CITY OF ALBUQUERQUE

Re: Renovation to an existing building Shell
10921 Central Ave. NE
Traffic Circulation Layout
Architect's Stamp 11-09-22 (L21-D030)

Based upon the information provided in your submittal received 11-14-22, the above referenced plan cannot be approved for Building Permit until the following comments are addressed:

TCL

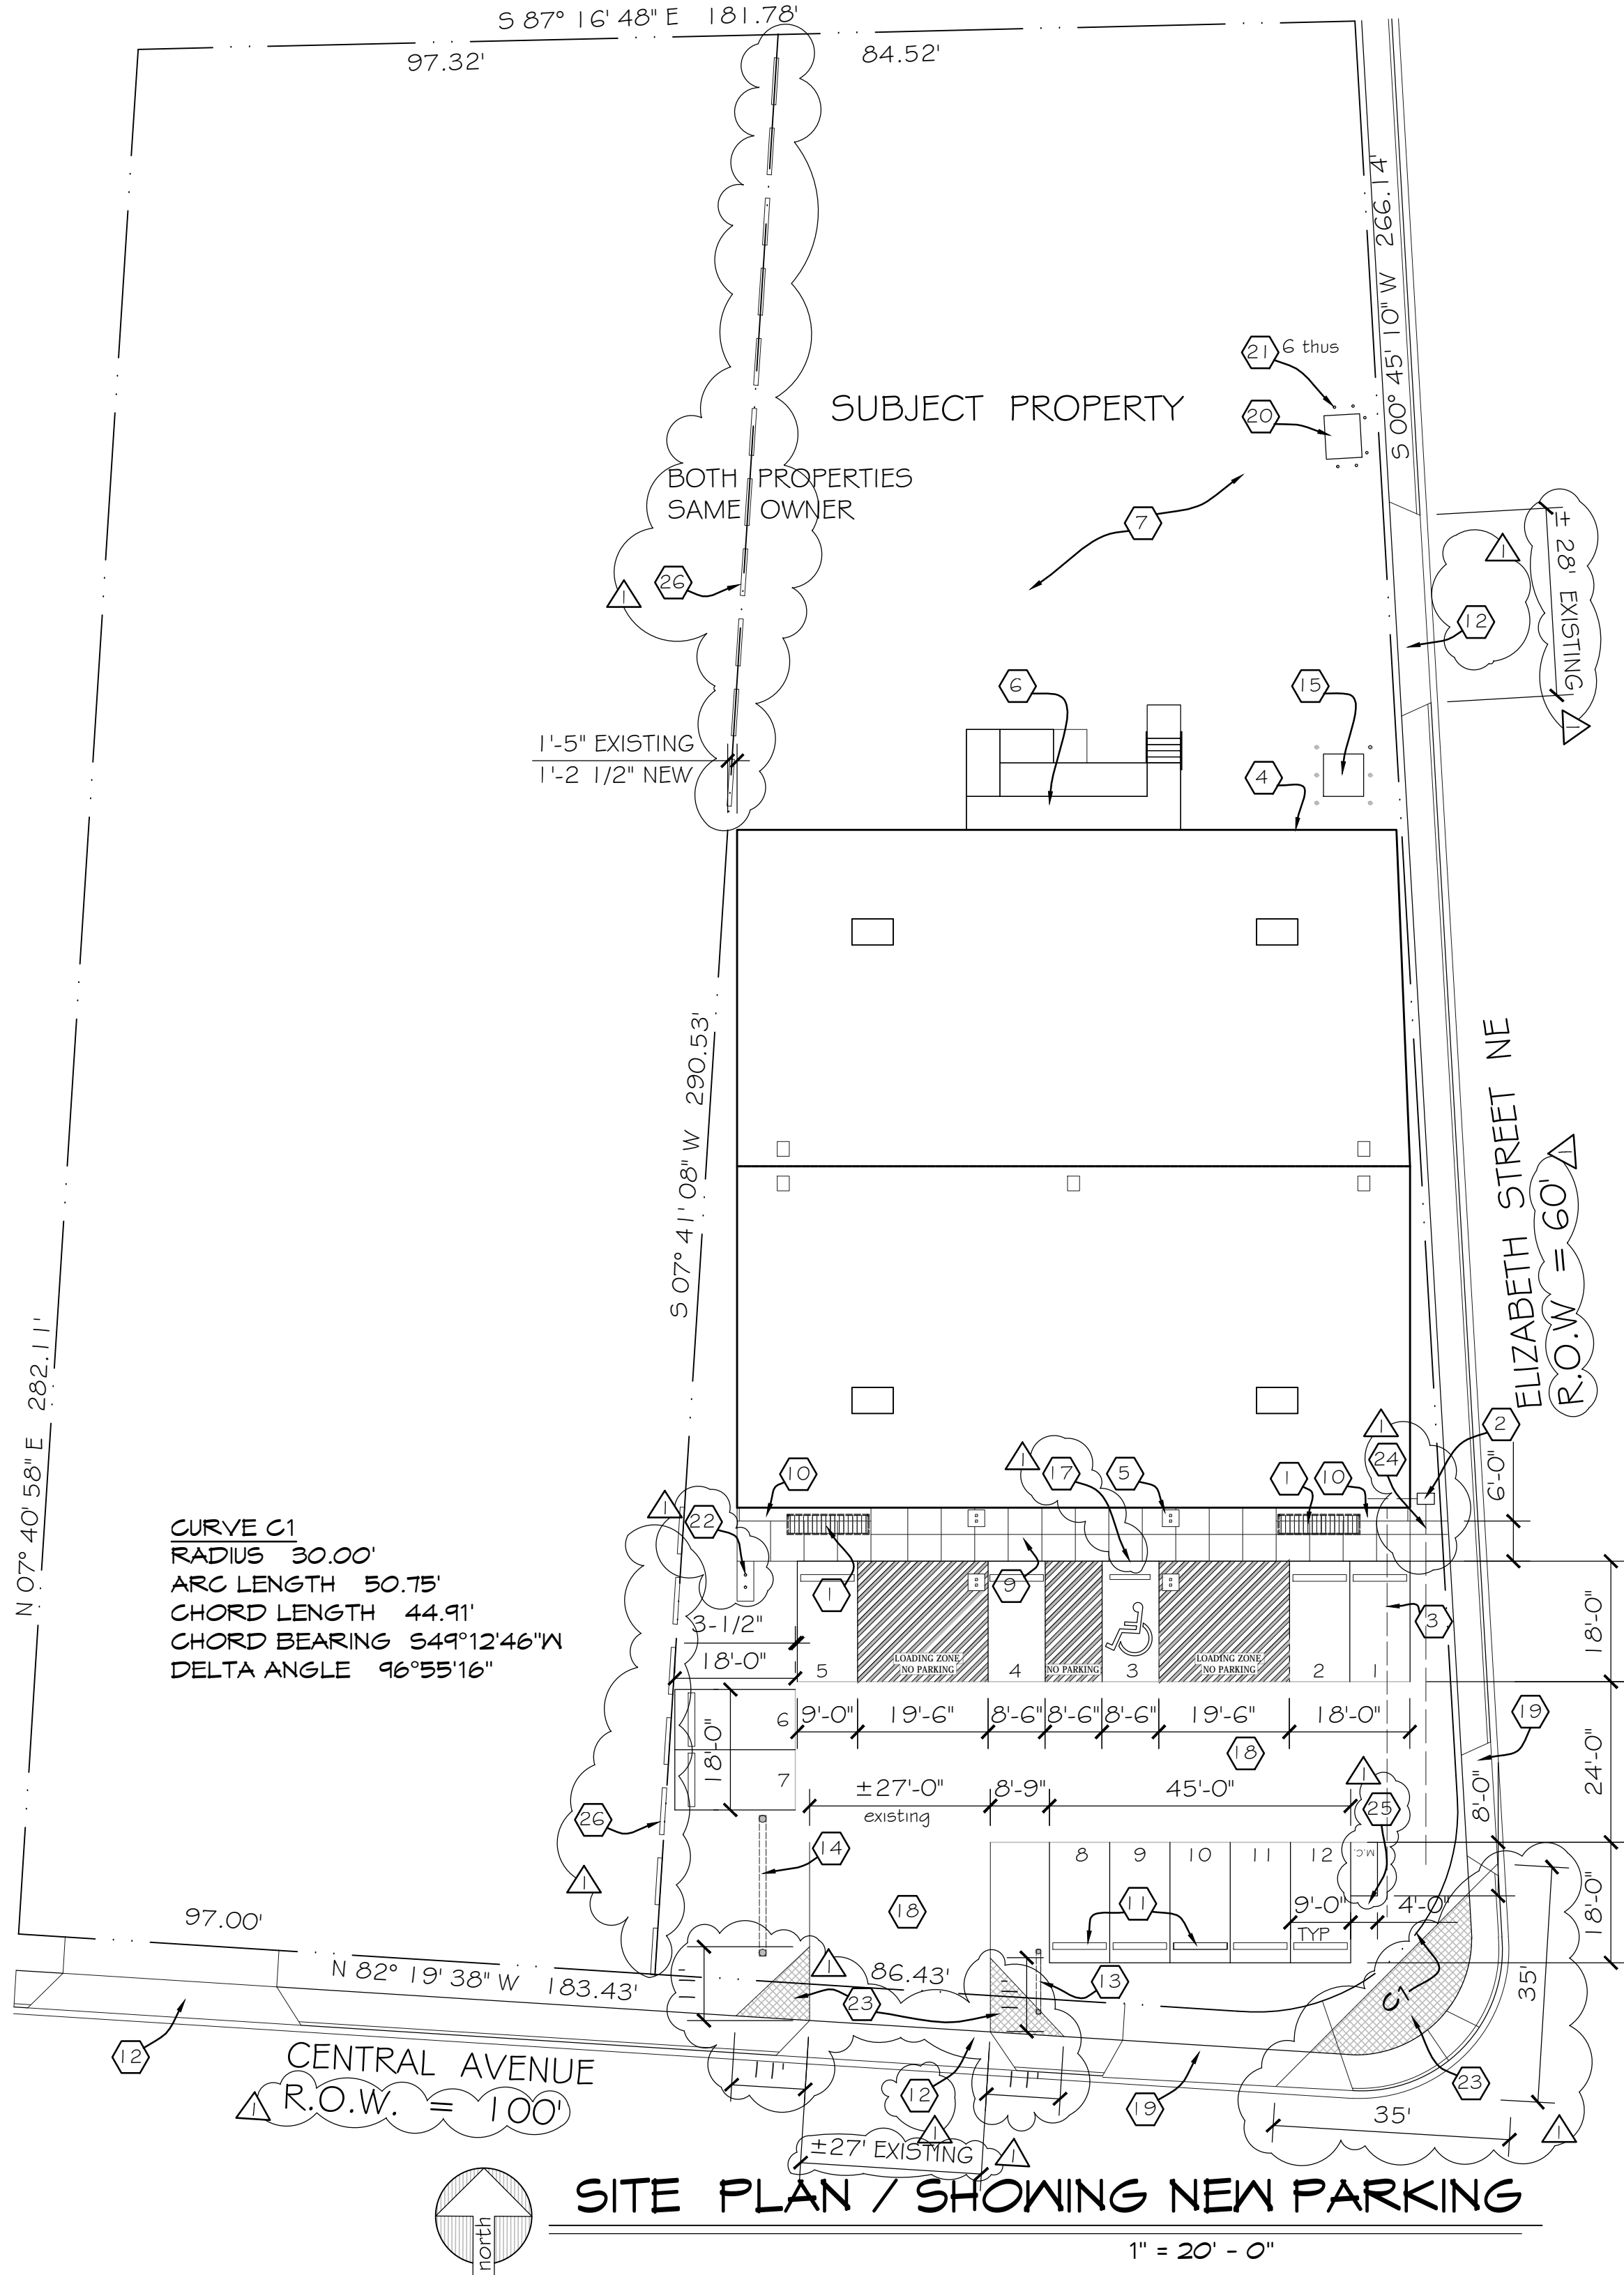
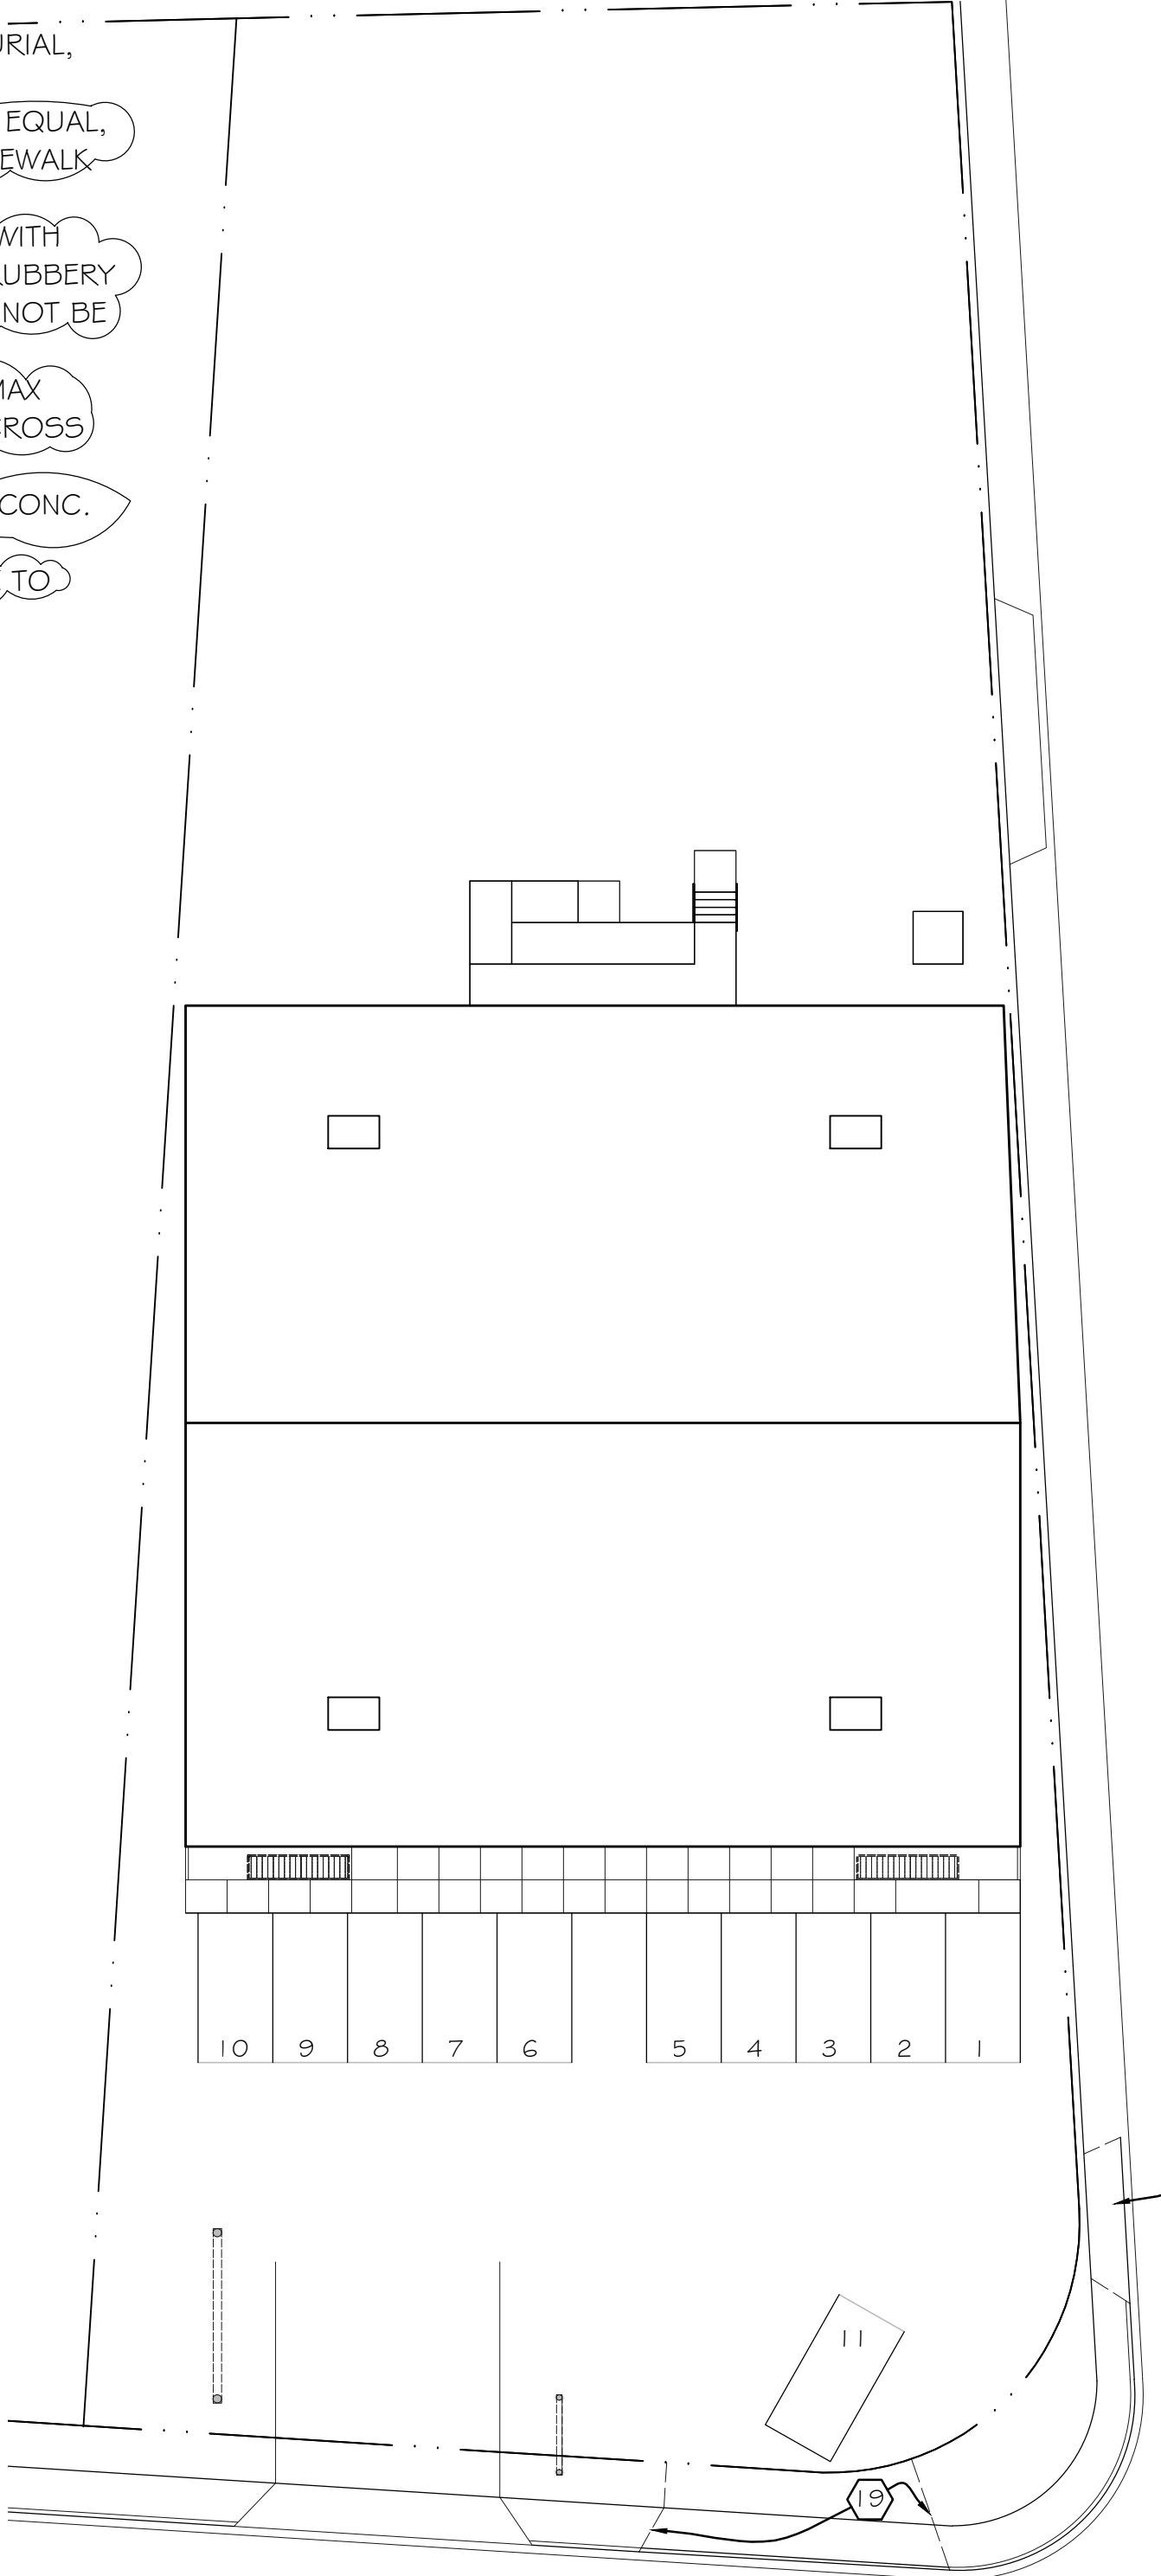
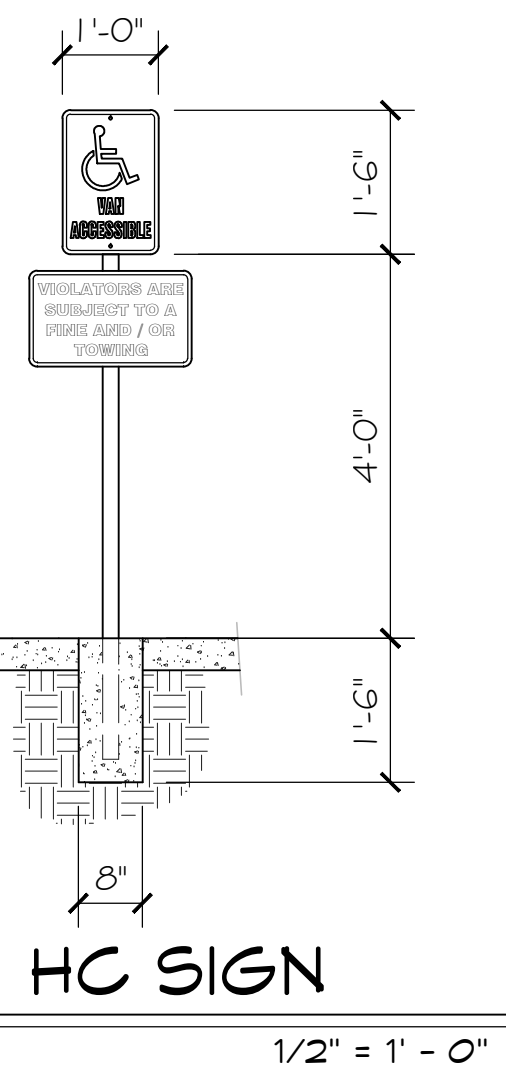
1. List the number of parking spaces required by the IDO as well as the proposed number of parking spaces including bicycle and motorcycle parking.
2. Identify all existing access easements and rights of way width dimensions.

3. Identify the right of way width, medians, curb cuts, and street widths on Central Ave. and Elizabeth St.
4. Provide the existing site accesses width.

5. Site accesses should be ADA compliant.
6. Please provide shared access agreement's with the adjacent property.
7. The ADA accessible parking sign must have the required language per 66-7-352.4C NMSA 1978 **"Violators Are Subject to a Fine and/or Towing."** Please call out detail and location of signs.

8. ADA curb ramps must be updated to current standards and have truncated domes installed.
9. Motorcycle parking spaces shall be designated by its own conspicuously posted upright sign, either free-standing or wall mounted per the zoning code.

10. The pavement marking "MC" should be shown in the opposite direction for motorcycles entering the parking space.
11. All bicycle racks shall be designed according to the following guidelines:

- a. The rack shall be a minimum 30 inches tall and 18 inches wide.
 - b. The bicycle frame shall be supported horizontally at two or more places. Comb/toaster racks are not allowed.

- c. The rack shall be designed to support the bicycle in an upright position. See the IDO for additional information.
 - d. The rack allows varying bicycle frame sizes and styles to be attached.

- e. The user is not required to lift the bicycle onto the bicycle rack.
- f. Each bicycle parking space is accessible without moving another bicycle.
- 12. Bicycle racks shall be sturdy and anchored to a concrete pad.
- 13. A 1-foot clear zone around the bicycle parking stall shall be provided.
- 14. Bicycle parking spaces shall be at least 6 feet long and 2 feet wide.
- 15. Show all drive aisle widths and radii. Some dimensions are not shown.
- 16. The minimum drive aisle dimensions are shown below

- 17. Define ADA pathways from the public sidewalk and from the ADA aisle to the building entrance, by labeling of ramps, flush pavement, dimensioning of pathways, doorways, etc.

- 18. Show the clear sight triangle and add the following note to the plan: "Landscaping and signage will not interfere with clear sight requirements. Therefore, signs, walls, trees, and shrubbery between 3 and 8 feet tall (as measured from the gutter pan) will not be acceptable in the clear sight triangle.

- 19. Key note 19: please reference COA std dwg 2430.

- 20. Please specify the City Standard Drawing Number when applicable.

- 21. Add a note stating "All broken or cracked sidewalk must be replaced with sidewalk and curb & gutter." A build note must be provided referring to the appropriate City Standard drawing.
- 22. Please provide a letter of response for all comments given.
- 23. Traffic Studies: See the Traffic Impact Study (TIS) thresholds. In general, a minimum combination of 100 vehicles entering and exiting in the peak hour warrants a Traffic Impact Study. Visit with Traffic Engineer for determination, and fill out a TIS Form that states whether one is warranted. In some cases, a trip generation may be requested for determination (**Contact Matt Grush: mgrush@cabq.gov**).
